Design Advice

Application Number 15/01693/F
Applicant's Name Mr and Mrs G Besterman
Application Type Full
Location Muddle Barn Farm Colony Road Sibford Gower Banbury OX15 5RY
Case Officer Nathanael Stock

Demolition of an existing dwelling and a range of large scale equestrian buildings and the erection of a replacement dwelling including associated works and landscaping (resubmission of 14/02157/F)

Figure 13  
Viewpoint photograph 2B  
Bridleway 348/2

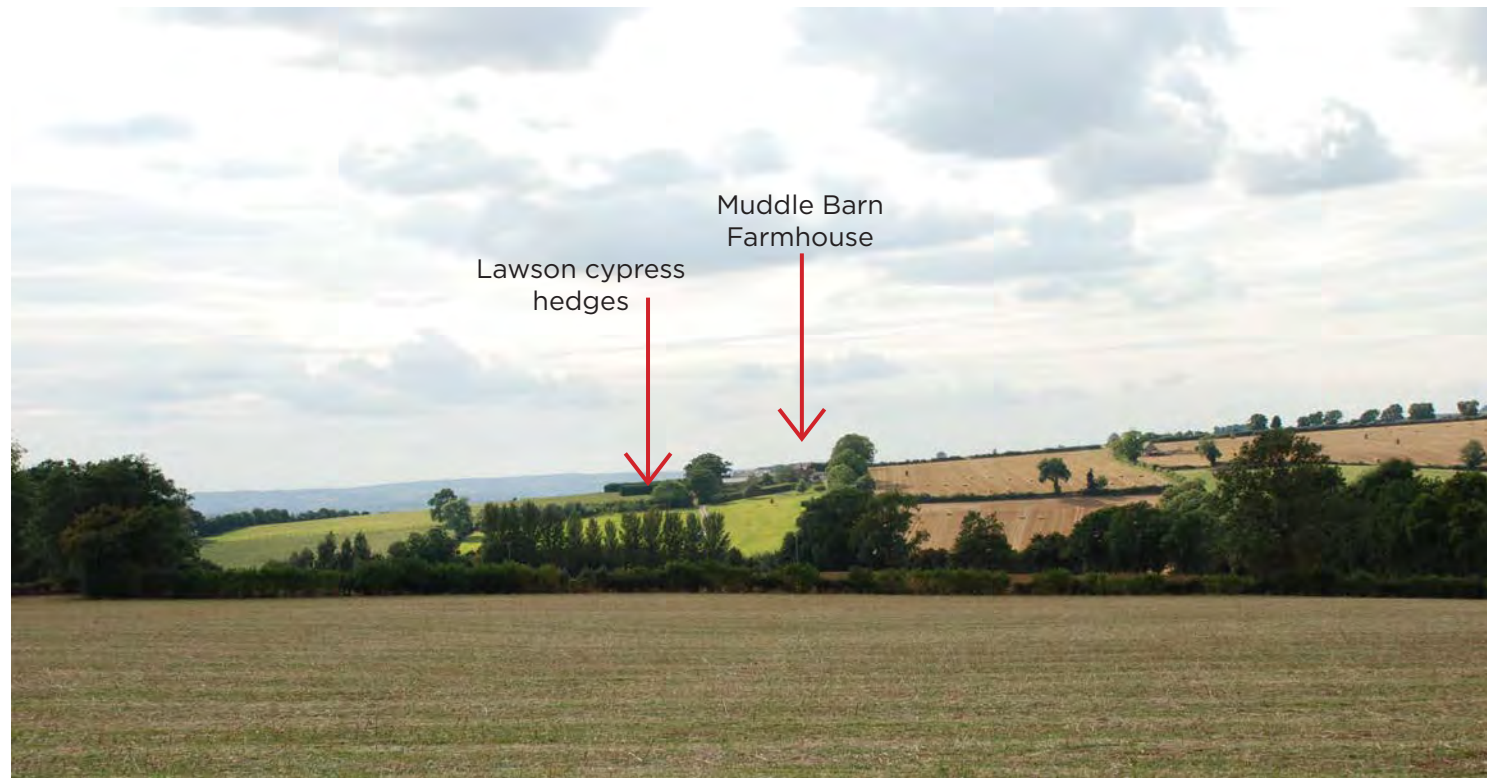
- Figure 13: As Figure 12 comments and the section on orientation.
- Figure 14: The horizon line should be softened.
- Figure 15: the house will be very prominent in this view, further planting may help to further integrate this large building with the landscape so that it is less dominant within its setting which is next to an area of high landscape value and the setting of the nearby conservation areas. The chimneys are also quite imposing in the views. The horizon line should be softened.

Datum 165.00m
SOUTH EAST ELEVATION

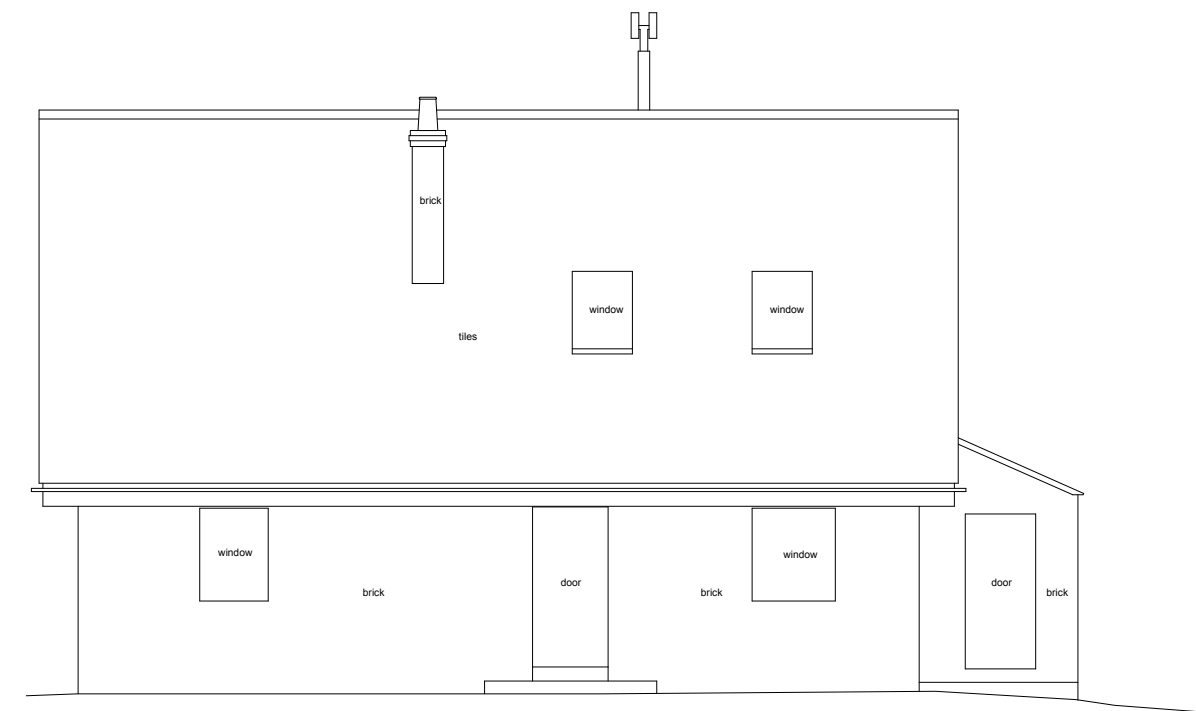
- Remove the central dormer to the south east elevation
- Query if chimney form is aesthetically correct in relation to roof hips.

Datum 165.00m
NORTH EAST ELEVATION

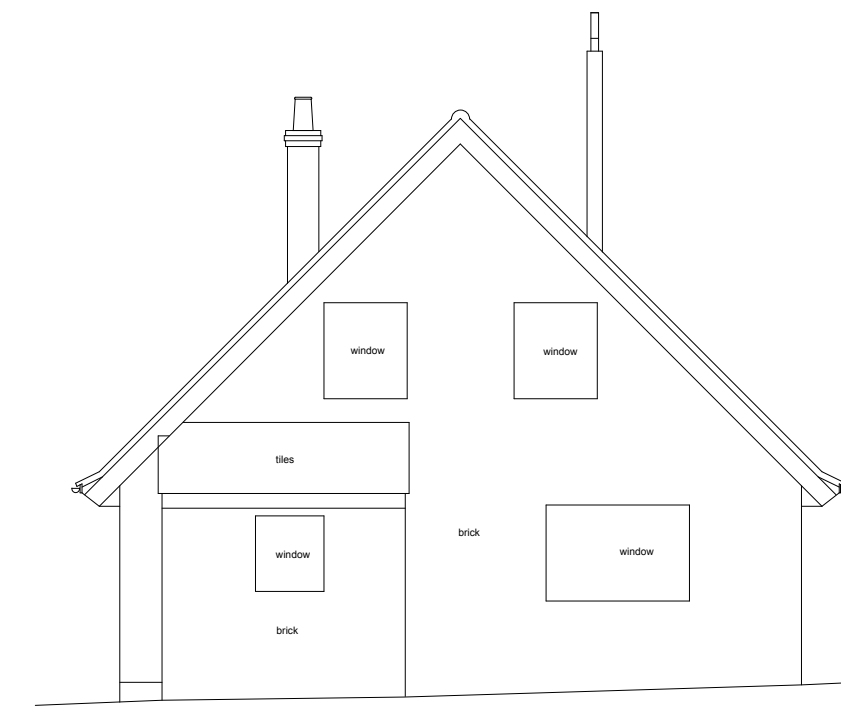
- Refer to comments on courtyard buildings above.
- Query if chimney form is aesthetically correct in relation to roof hips.
- Move the dormers over the windows on the elevation below.
- The thin windows look mean and highlight an oddity in the rhythm, proportion of the elevation.
- The proportions, rhythm and solid/void ratio are not fully resolved.

Datum 165.00m
NORTH WEST ELEVATION

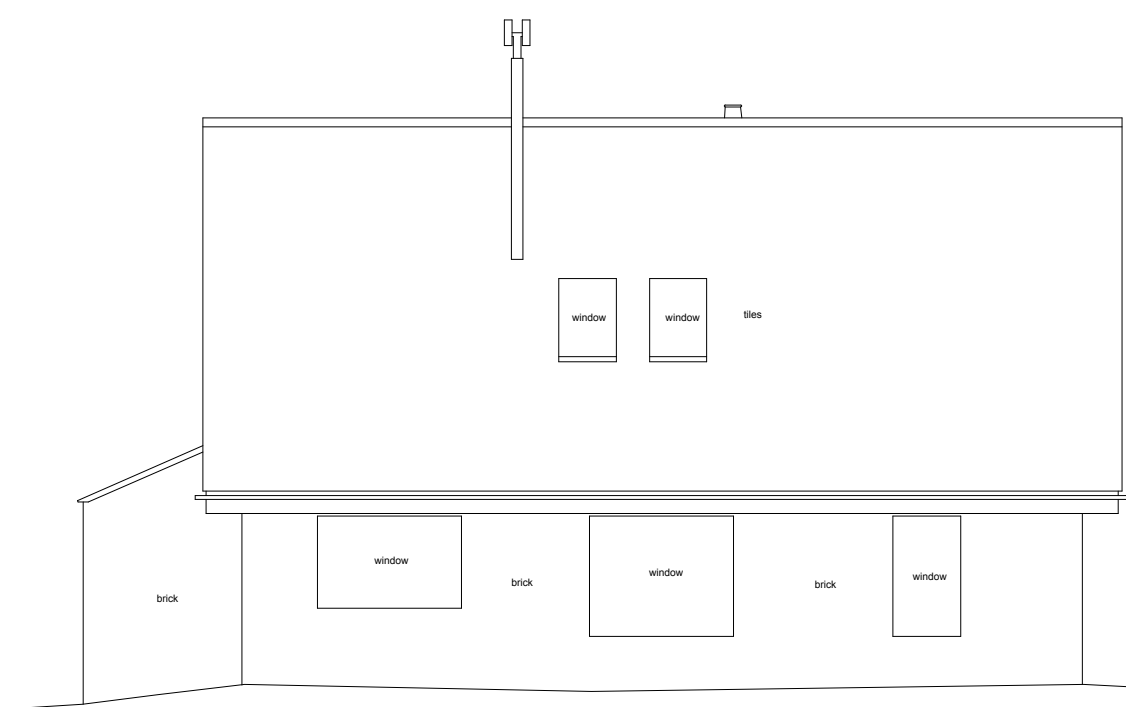
- Remove the central dormer to the north west elevation

- the stair could be lit by a lantern light allowing the dormer on the north east elevation to light the bedroom.
- Query if chimney form is aesthetically correct in relation to roof hips.
- NB. Any amendments to elevations will have a knock on effect on the plan form
- Refer to comments on courtyard buildings above.

Datum 165.00m
SOUTH WEST ELEVATION

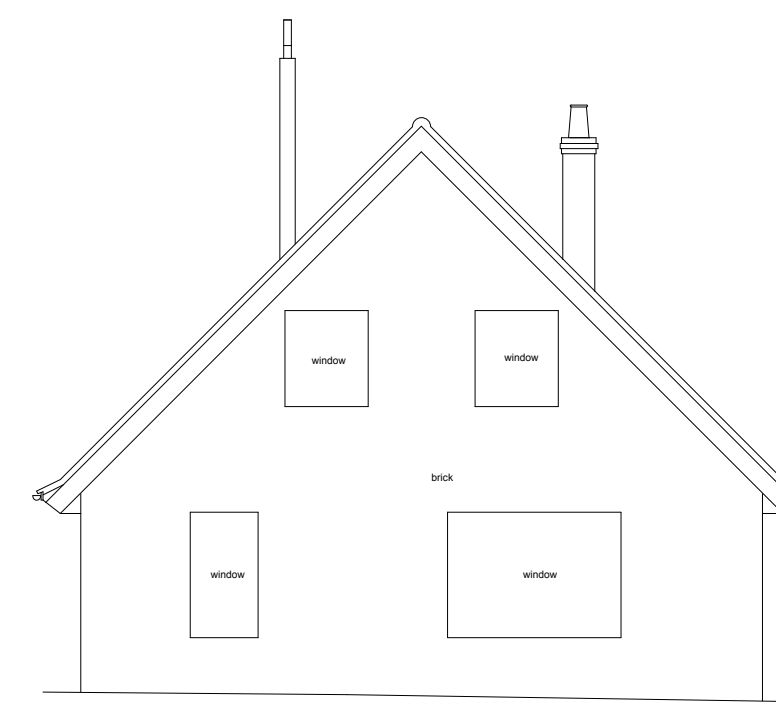
- The relationship of the eaves of the kitchen extension to the string course of the main house looks very similar and needs to be stronger. There is a drafting error: the south west elevation shows the lantern above the parapet but this is not shown on the north west elevation. The lantern light would be better hidden behind a parapet.

- Remove the dormers to the north west and south east elevations – the stair could be lit by a lantern light allowing the dormer on the north east elevation to light the bedroom.
- Move the dormers over the windows on the elevation below.
- Query if chimney form is aesthetically correct in relation to roof hips.
- Tall hipped roof behind kitchen appears to steep and dominant – see comments on this juxtaposition of building above.
- The height of the glazed doors in the kitchen look overly tall and there is not enough solid wall between the top of the openings and the start of the parapet.
- The relationship of the kitchen parapet to the string of the main house is awkward.
- The width of the bay needs careful handling as part of the whole elevation – rhythm/solid/void/proportion.

Figure 16  
Viewpoint photograph 5  
Footpath 347/2

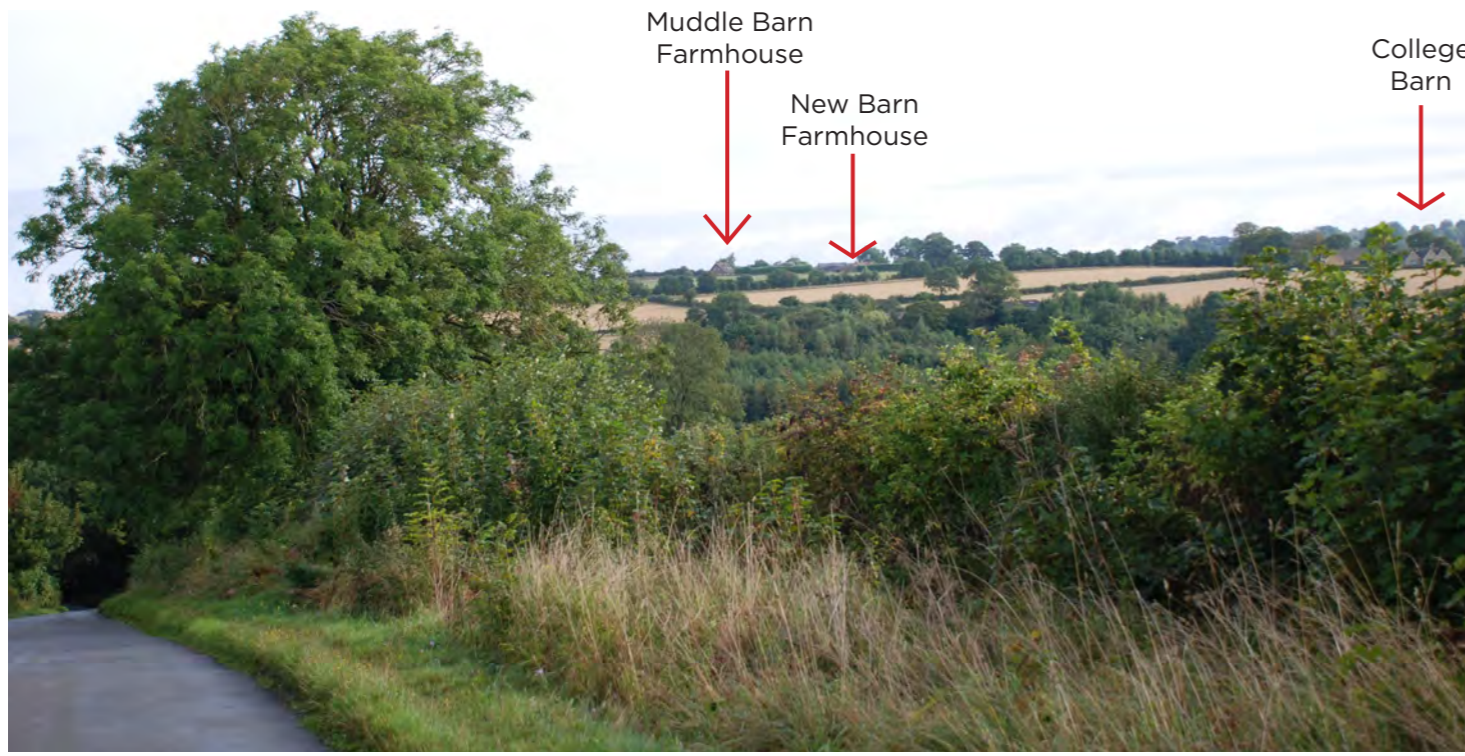
- Figures 16: as comments for Fig 15.
- Figure 20: The views of the building need further softening to the front to break down its very large scale and at the back to soften the skyline.
